## DECISION DELEGATED TO HEAD OF PLANNING

**Application No:** H02-0285-24      **Applicant:** Miss J Blackbird

**Proposal:** Proposed 2-storey 3-bedroom detached chalet bungalow with associated double garage, parking and private amenity space

**Location:** Rear Of 12 Peterborough Road Crowland Peterborough

Project	Proposed Dwelling		
Drawing Title	Proposed Floor Plans		
Address	12 Peterborough Road, Crowland, PE6 0BA		
Drawn By A. L. Sutton	Paper Size A3	Date December 2023	
Project Name 048	Drawing Number 003	Revision -

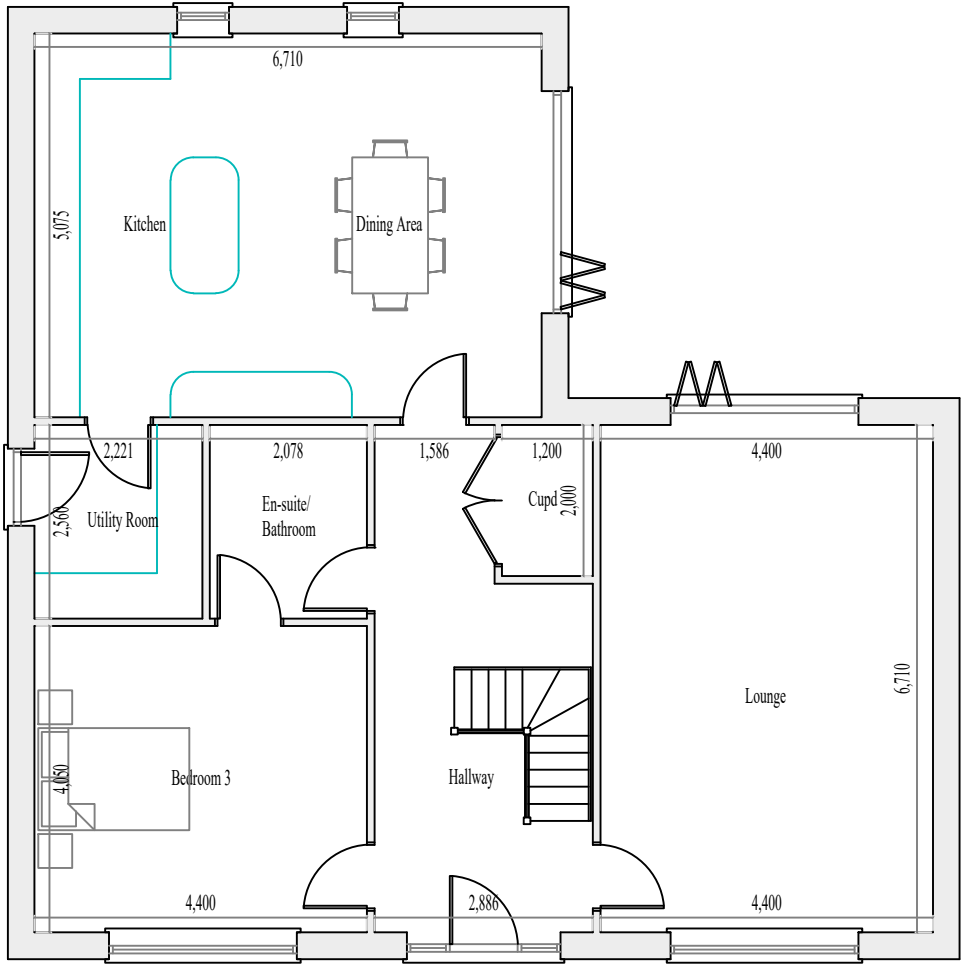
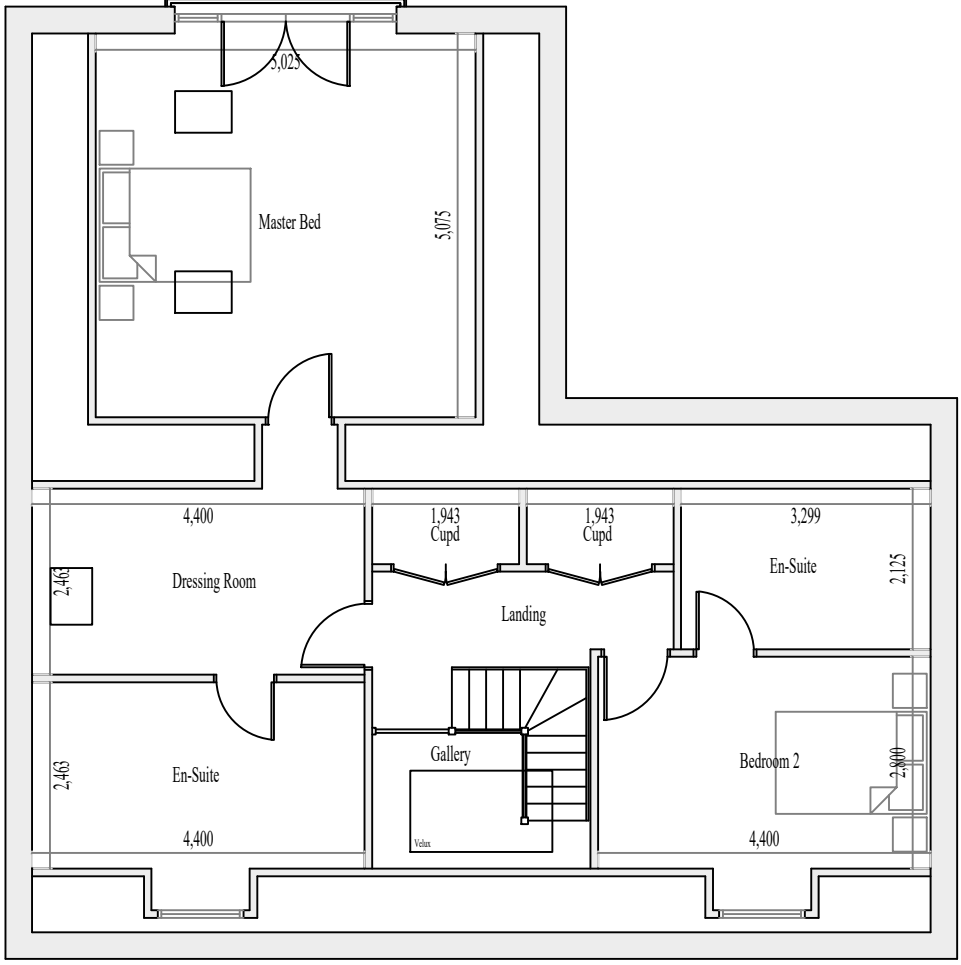
There is considered to be a material overlooking impact from the proposal. The rooflights on the northern elevation roof slope serve a master bedroom and are located 1.6 metres above ground level. Therefore, it is considered that the majority of adults would be able to overlook the rear garden of 10b Peterborough Road. It also considered that there will be an overlooking impact to 14 Peterborough Road to the south of the site. This is due to the need to raise finished floor levels 1 metre above ground level. As a result, the bi-fold doors serving the ground floor dining area would be able to overlook the dwelling and rear garden of 14 Peterborough Road above the existing 1.8 metre high fence. An overlooking impact would also be generated from the patio that is adjacent to the dining room doors.

Additionally, an overlooking impact will impact the rear garden of 12 Peterborough Road and 14a Peterborough Road from the west facing first floor en-suite and bedroom windows. Furthermore, there is considered to be a material overlooking impact to the frontage of 10 Blackbird Close, to the east beyond the rear boundary.

Proposed Front Elevation (West)
Scale 1:100

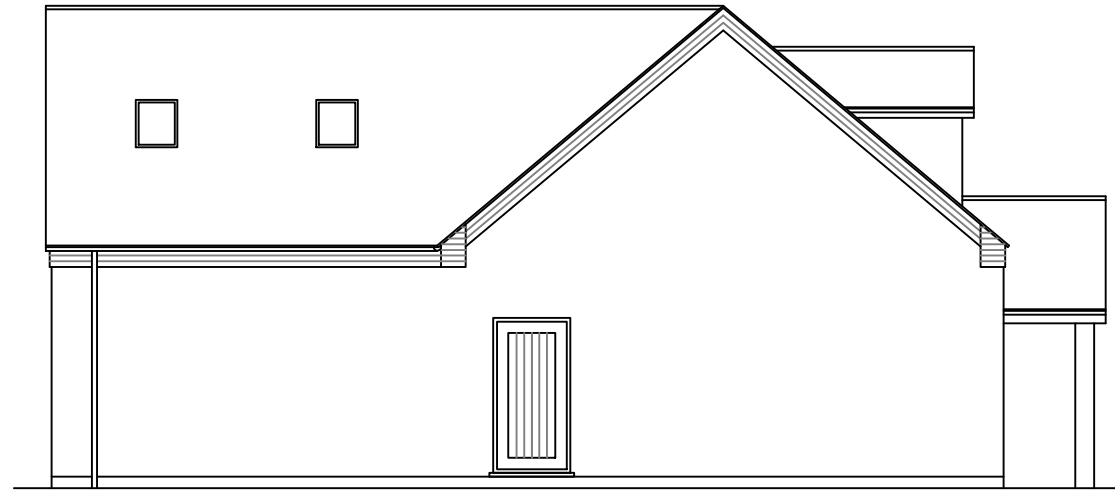
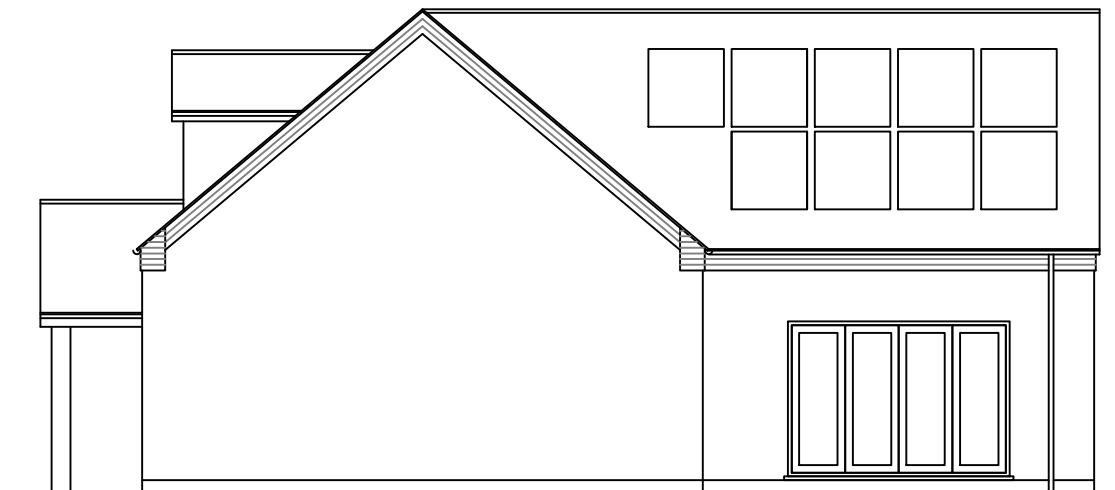
The need to raise finished floor levels 1 metre above ground level means that the chalet bungalow will materially higher in height than 12 Peterborough Road to the west of the site frontage. The submitted plans show the proposed streetscene with the proposed dwelling creating an imposing impact on the parent dwelling leading. This is considered to constitute an incongruous development that materially impacts the character of the surrounding area.

Project	Proposed Dwelling		
Drawing Title	Proposed Landscaping Plan		
Address	12 Peterborough Road, Crowland, PE6 0BA		
Drawn By A. L. Sutton	Paper Size A3	Date December 2023	
Project Name 048	Drawing Number 006	Revision -

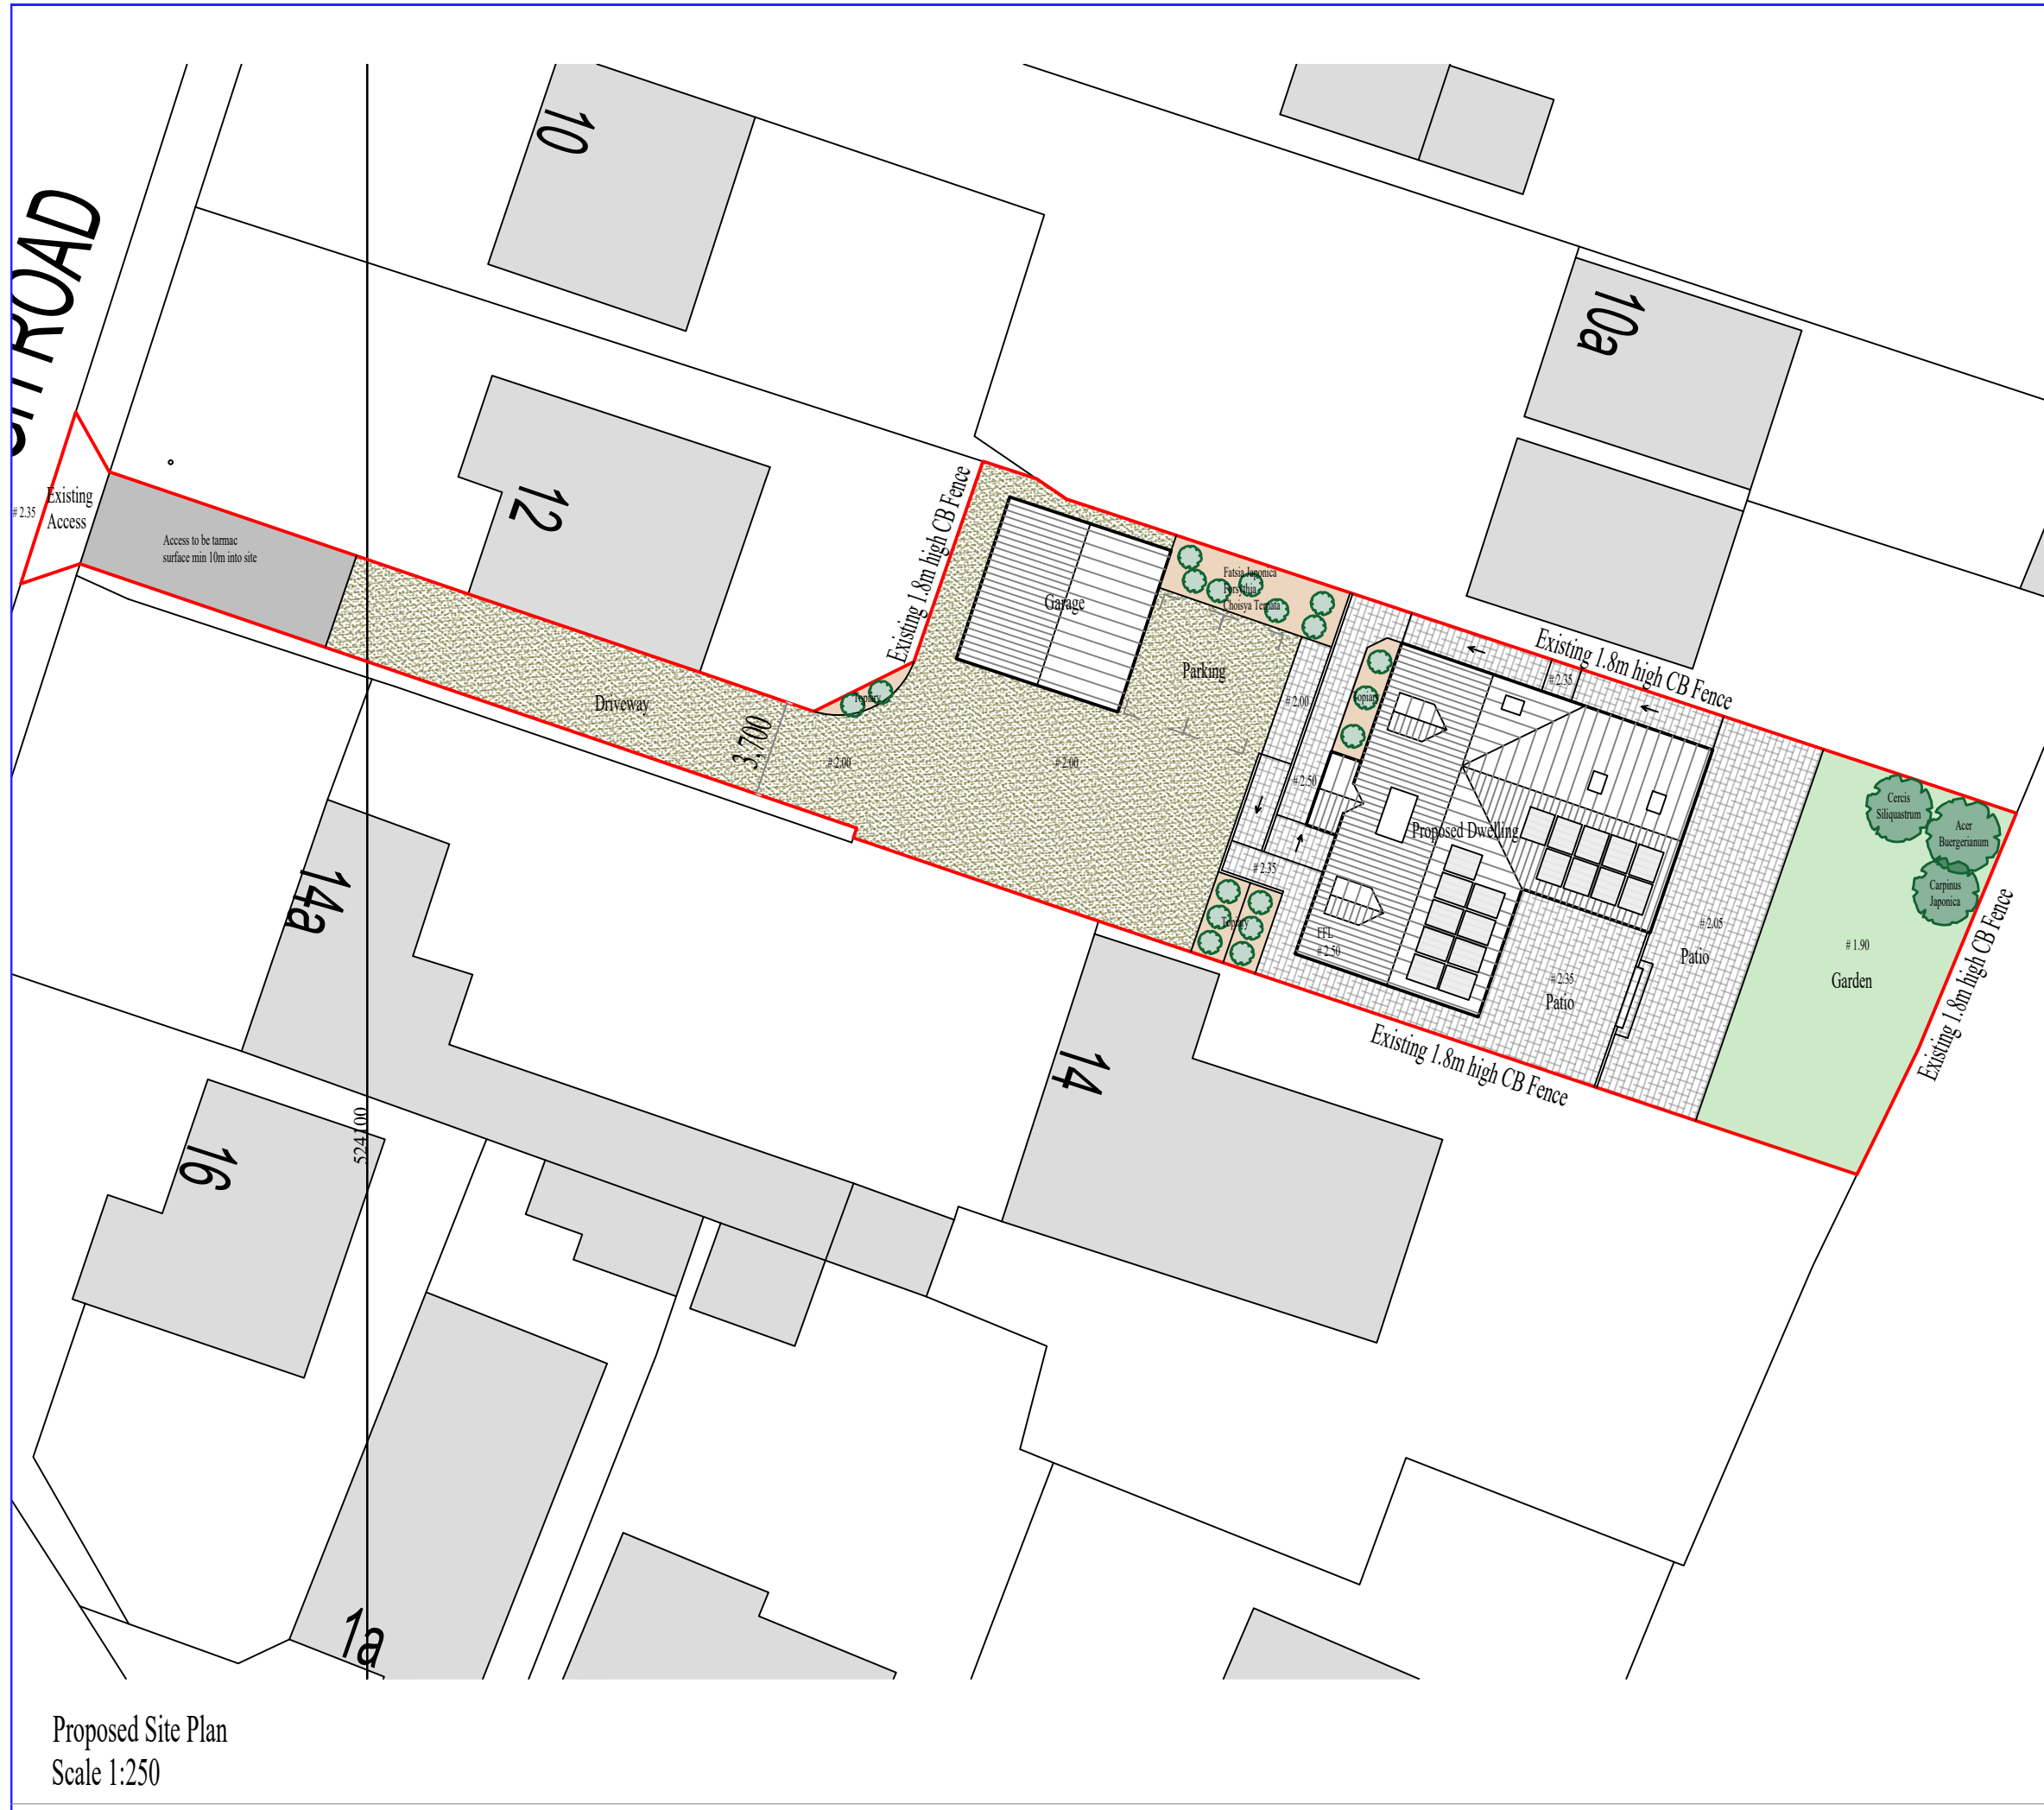
*"In principle, the proposed development would seem acceptable, as there is sufficient parking and turning within the site to allow vehicles to enter and leave in a forward gear. However, the current width of the existing access is not acceptable to accommodate the two-way movements of vehicles for the proposed dwellings and the host dwelling, where vehicles are waiting on Peterborough Road*

*"Therefore, in order to mitigate concern for highway safety, we would ask the applicant to show the width of the access for the first 10.0 metres to be 4.1 metres as a minimum to provide suitable access arrangements. We would also ask that the applicant to show what parking arrangements can be accommodated for the host dwelling."*

It is considered that the applicant can overcome the concerns of the County Highways & SUDS Officer if they were to submit amended plans to address access width, parking provision and manoeuvrability concerns.
